Project Title: Hotel Chaco Building Permit # _____ City Drainage #: J13/D066

To: gmeans@highmesacg.com
Subject: J13D066 - Hotel Chacao

Given the sad news, it makes sense as to why you are taking over this project – Hotel Chaco. When I first reviewed it, Jeff had walked me through all the calculations and drawings. I am reviewing the revised plans, and understand that some of the proposed changes are to use water quality manholes in lieu of the cisterns. Given the circumstances, this email is being sent in lieu of an attached comment letter in order to expedite the review. Here are some questions regarding the changes:

C1.101

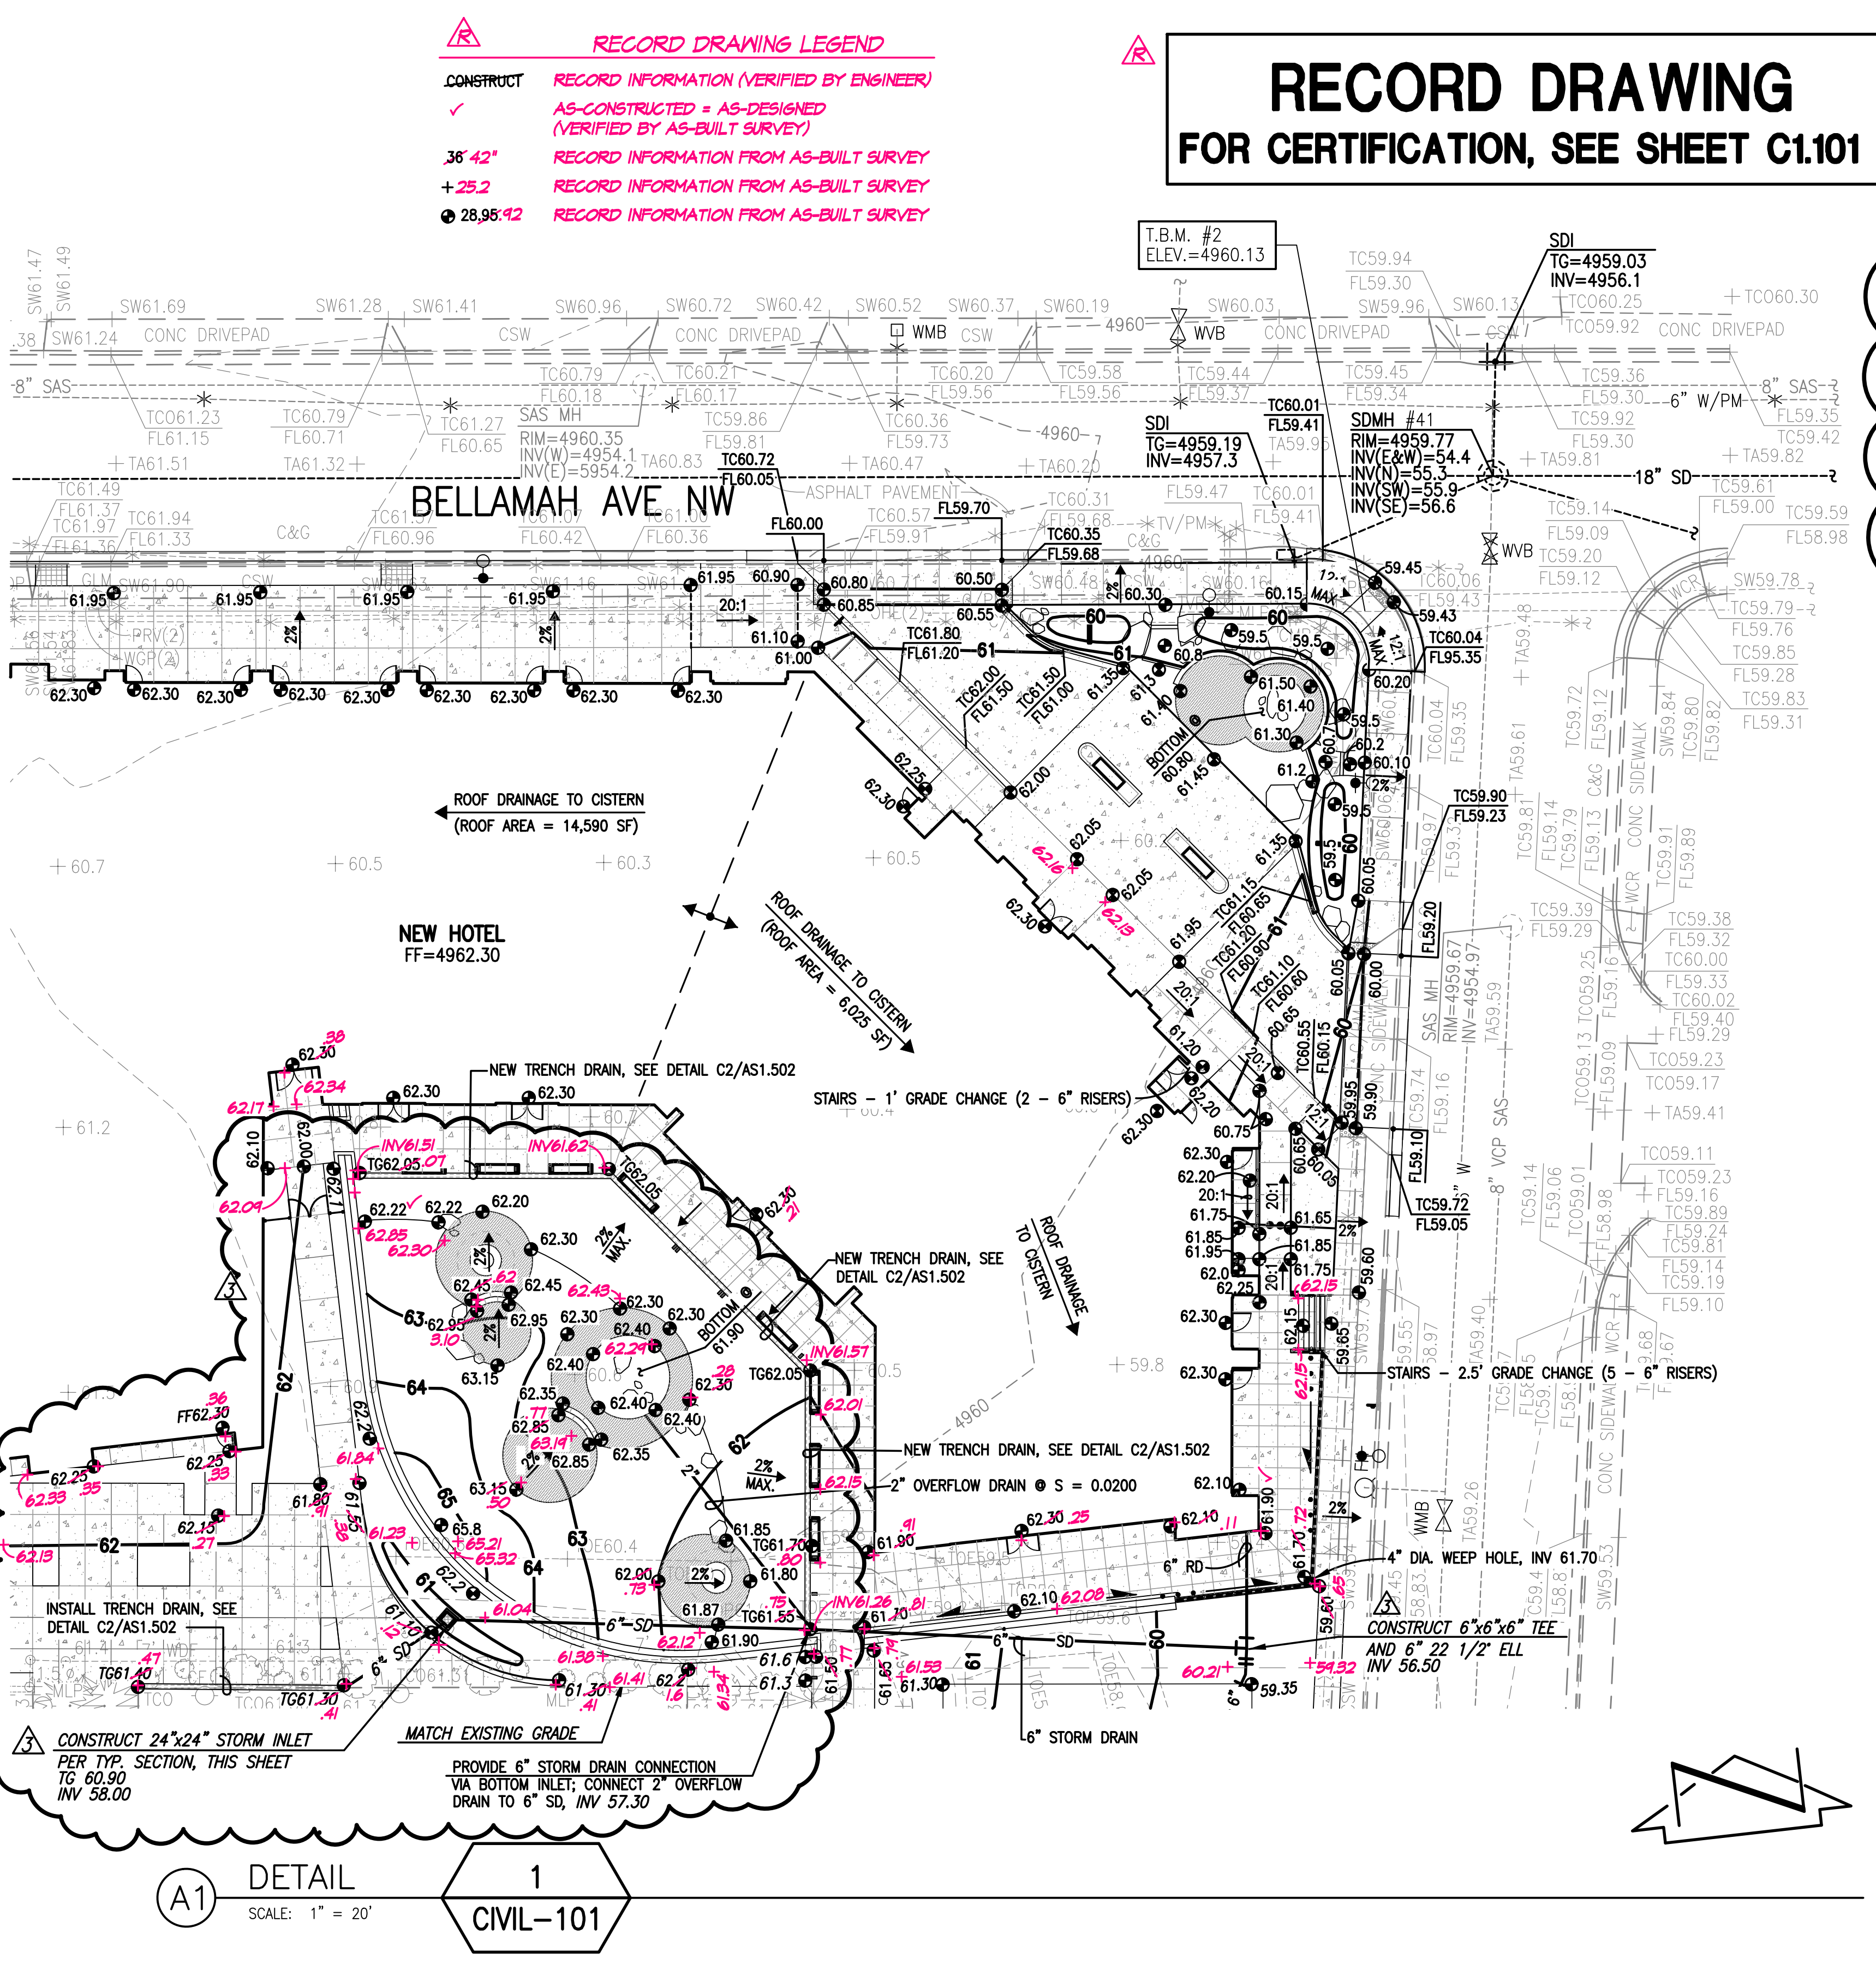
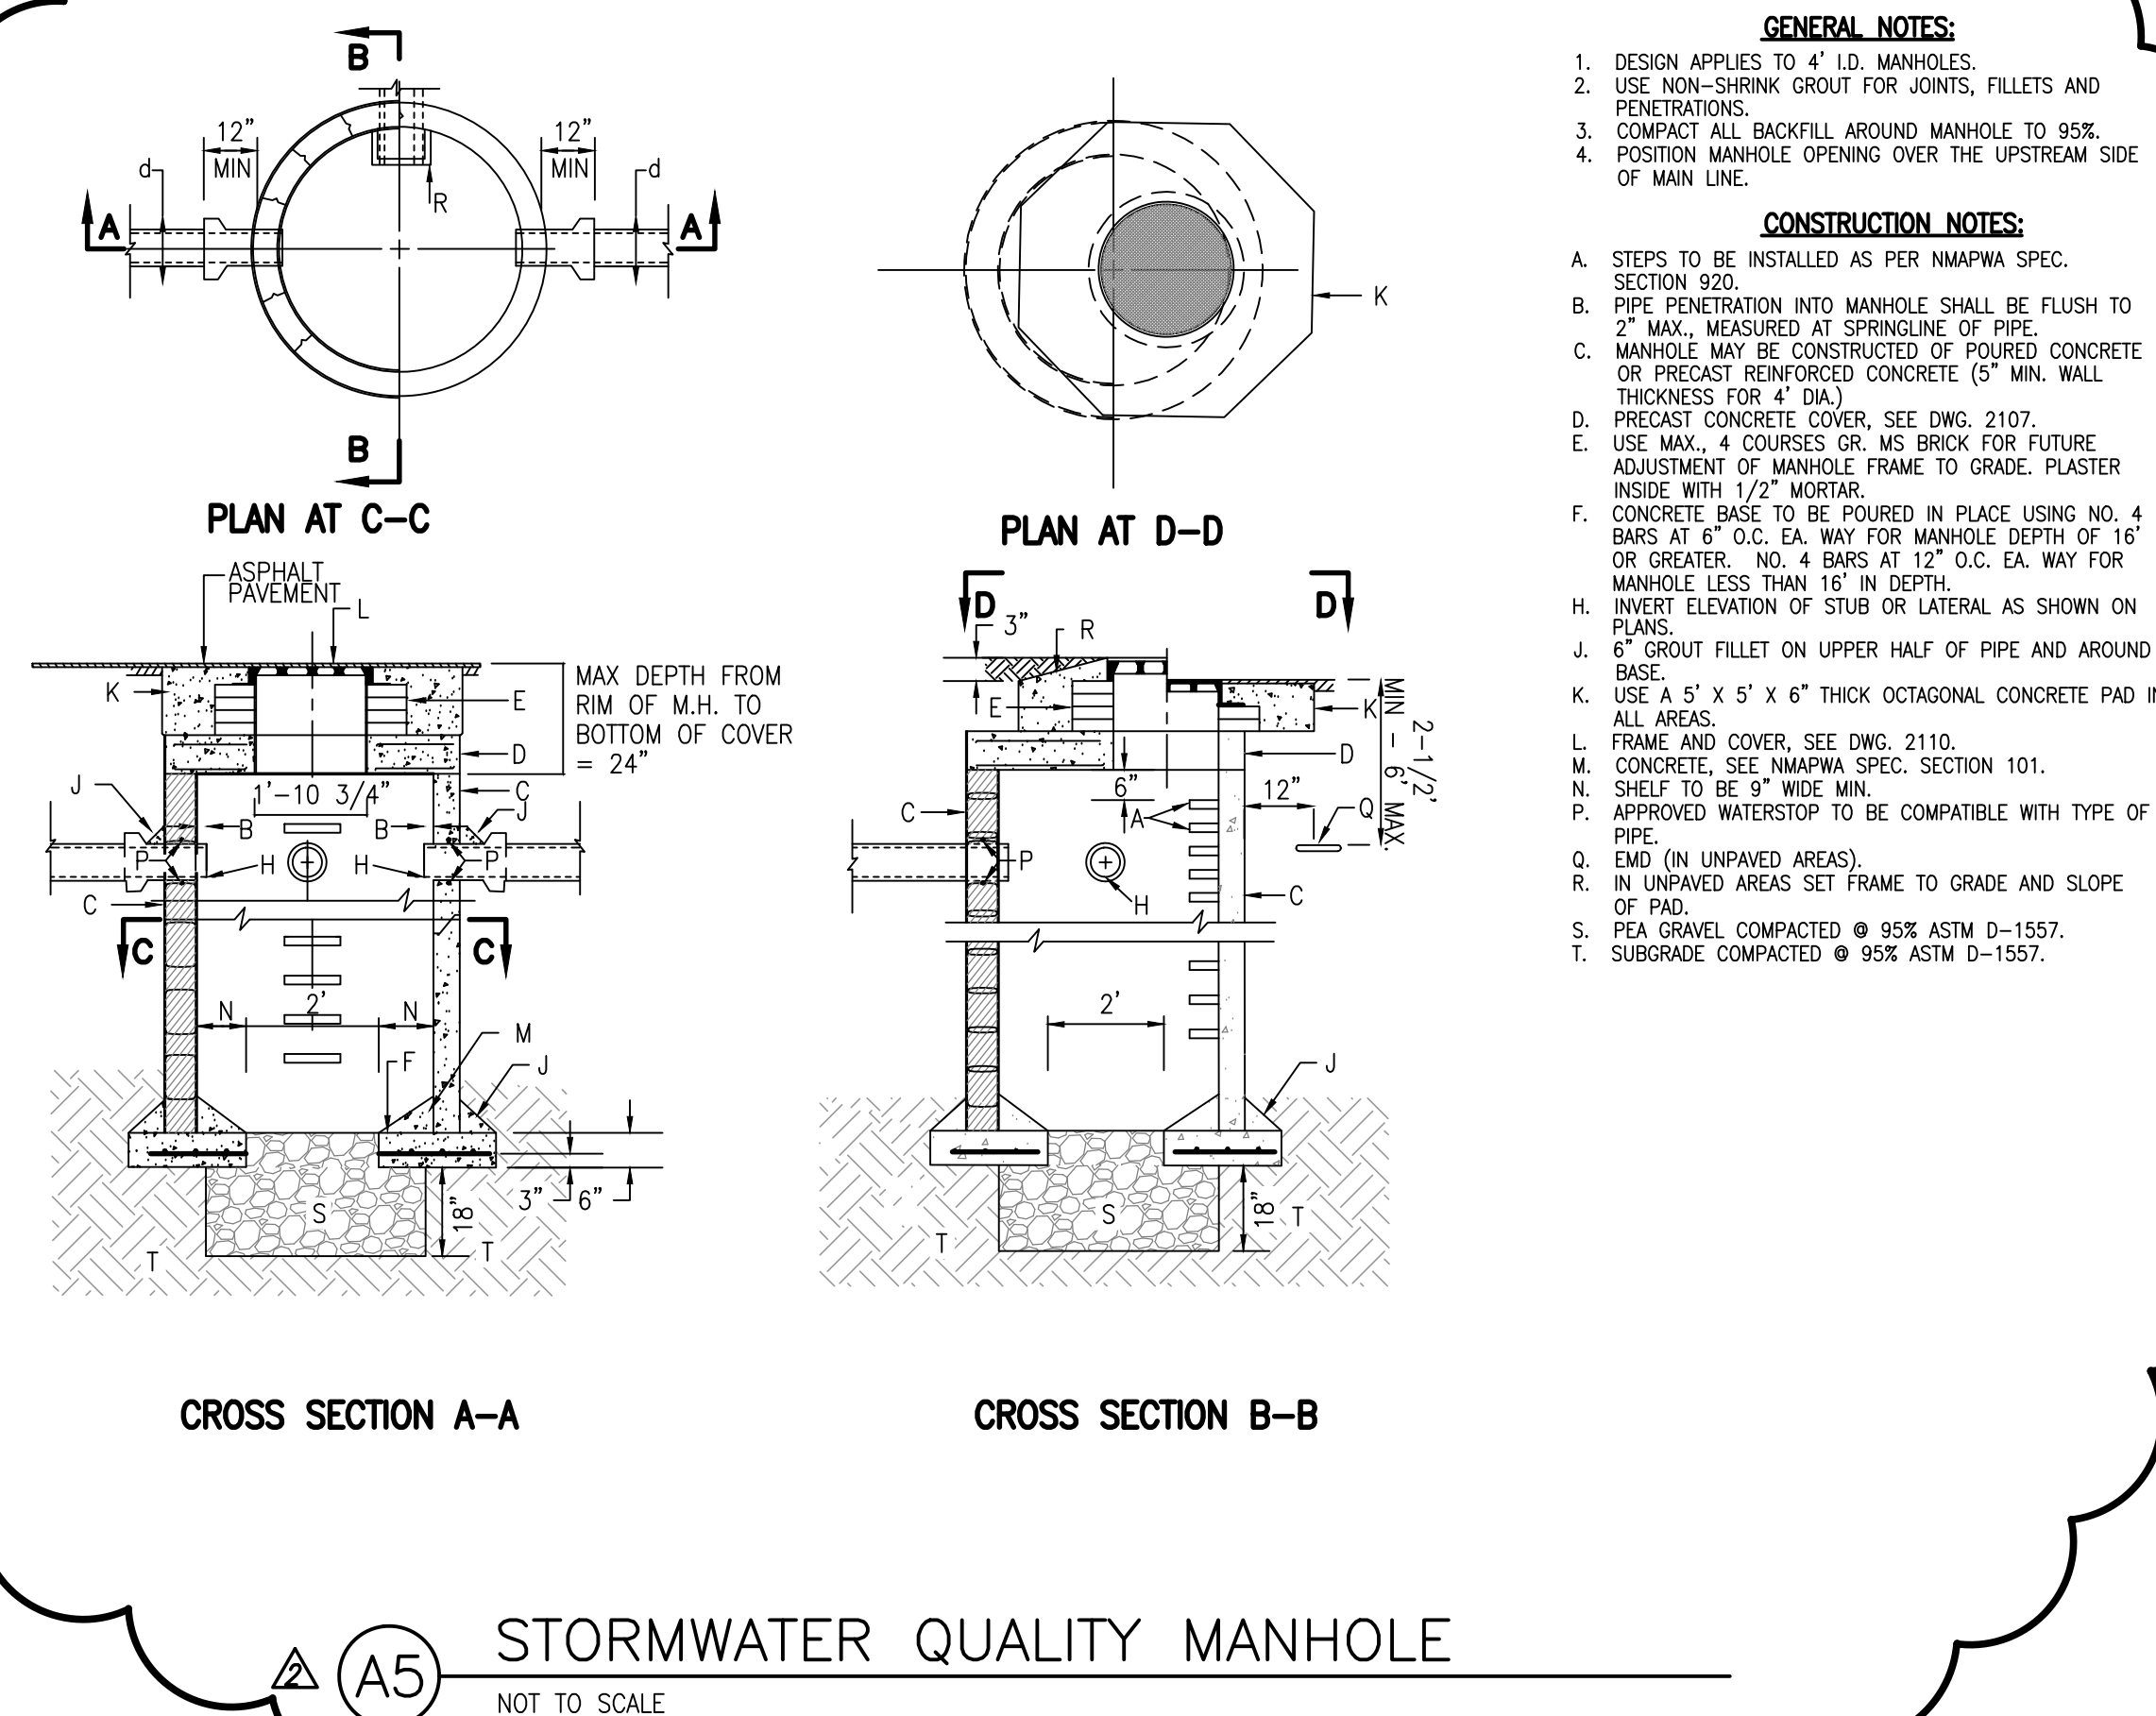
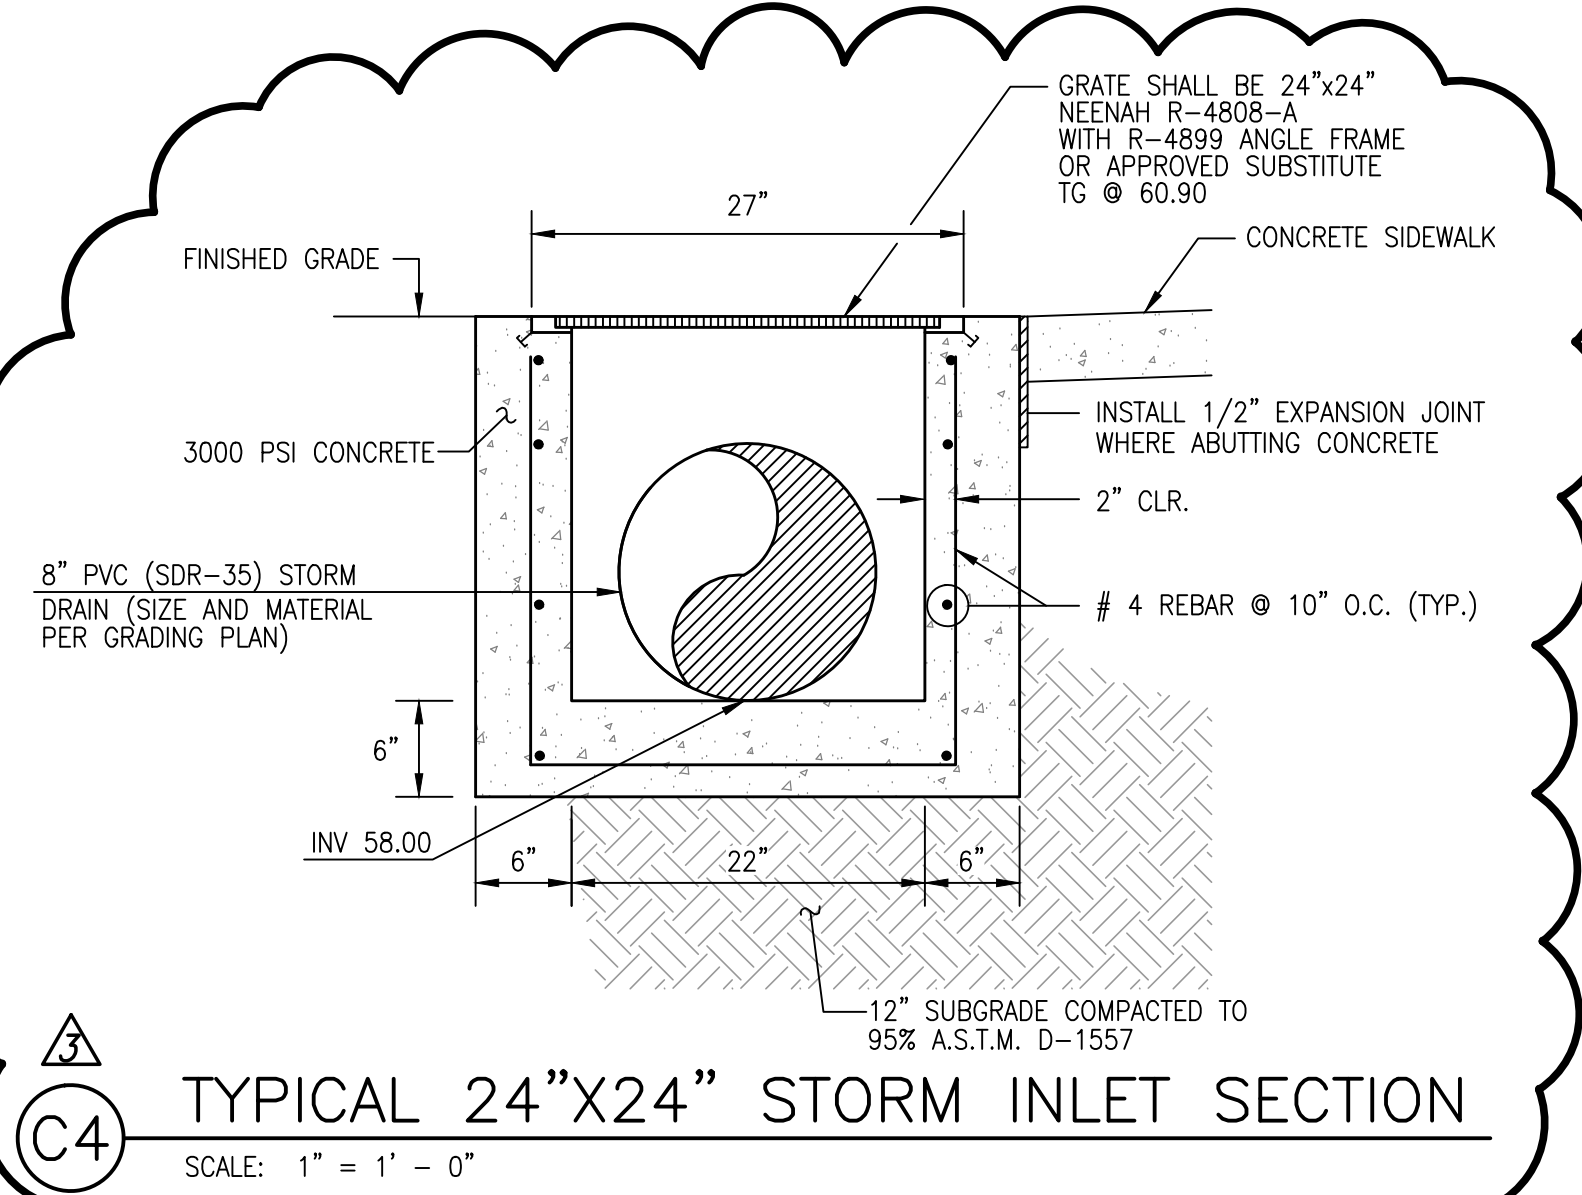
- 1) Original calculation sheet show that the cisterns were used to catch the first ½" of runoff, (In the Valley, discharge is limited to either 2.75cfs/acre, or detain the first ½" of runoff.) Do the proposed Water Quality Manholes capture the same volume of runoff? If the new Manholes are not holding the same volume, then are you going to limit the discharge rate?

- 2) The Manhole details show pea gravel at the bottom. Is the intention to allow runoff to percolate into the soil? If so, we need a letter/email from the Geotech stating that such seepage into the soil will not undermine the structural foundations.

- 3) The site is adjacent to a flood zone, and this has caused some concerns. If flooding occurs in 20th street, then discharging into 20th street will worsen the flooding depth and limits. The cisterns were allowed because water could be pumped out of them when any flooding in 20th street had subsided.

- 4) If 20th Street floods (and it often does with lesser than 100-yr. storms), the proposed sidewalk culvert could be allowing street flows into the manhole and filling the manhole faster than flows from the site itself.

Look forward to any additional volume you are able to find on the site to offset the cisterns. When we spoke about them last time i did not know that the site is within, and feeds, directly into an AH Zone.. I thought the cisterns were to offset first flush volume, which is why I suggested the WQ manholes to enhance the treatment effort like on your BMW site and a couple of other APS projects.

With the AH Zone impact, you will in fact need to provide the volume that was in Jeff's original plan. This site is a big contributor to the basin, and several buildings are already clipped by the Zone; there is also a building with a recently approved LOMA that could be impacted.

Alternatively, you could also consider maximizing the volume of your site as much as possible, and then present an analysis of the basin to show that the impact to the elevation of the BFE is negligible. For example (and using very rough approximations), the surface area of the floodzone is about 370,000 SF. A negligible rise of 0.05 inches gives an allowable volume of about 1500 CF.

How much water would have been captured by the cisterns? (i.e. how much more water are you now proposing to feed into the floodzone?)

Keep in mind that even if the amount is small, we will still need you to maximize the retainage for first flush to the extent practicable, and then we can consider the wq manholes..

As for the Hotel Chaco resubmittal, I came in an met with Abiel several weeks ago regarding the proposed deletion of the cistern. The reality of cisterns is that during the rainy season they are usually full, so the associated volume may not be there for any retention. For this site, most of the landscaped areas will be depressed with an unquantified volume of storage. We propose that this meets the intent of the ordinance. Abiel requested we provide the water quality manhole to provide pollutant control for the roofwater (bird poop) which is what we did. If you need buy-in from the Geotechnical engineer, we can pursue that.

As for the sidewalk culverts, Abiel suggested them in lieu of the curb penetrations previously proposed because we understand that they are discouraged and problematic. Yes, they can run backwards if the street is full, but that is no different than the curb penetration scenario in the previous submittal. We will see if there's a way to reduce or limit the potential.

As for limiting discharge, the plan does have several landscaped areas that are depressed, and we understand that the landscape architect intends to make the depressions a bit deeper than designed.
